CITY OF ALBUQUERQUE

June 14, 2024

Re: Seven Clover Dispensary
3641 12th St. NW
30-Day Temporary Certificate of Occupancy
Transportation Development Final Inspection
Engineer's Stamp dated 05-15-24 (G14-D062)
Certification dated 06-05-24

SHEET TITLE
CIVIL SITE PLAN
SHEET NUMBER
CS-101

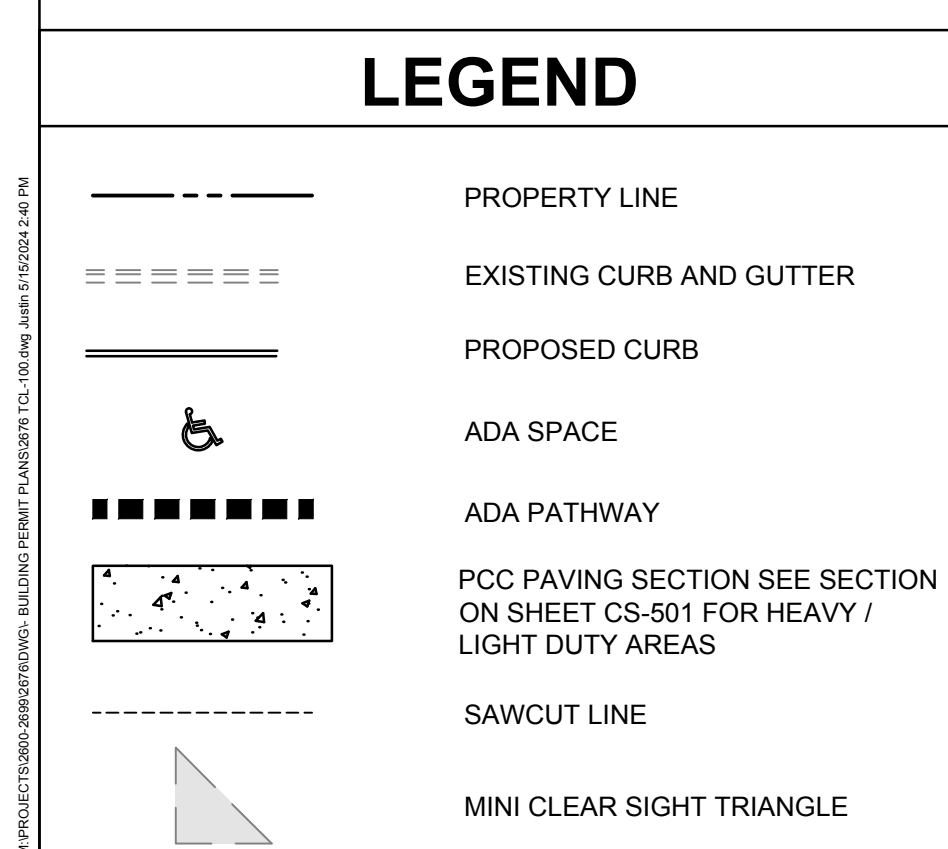
- The ADA accessible parking sign must have the required language per 66-7-352.4C NMSA 1978 **"Violators Are Subject to a Fine and/or Towing."** Please call out detail and location of signs
- Anchor down bike rack.
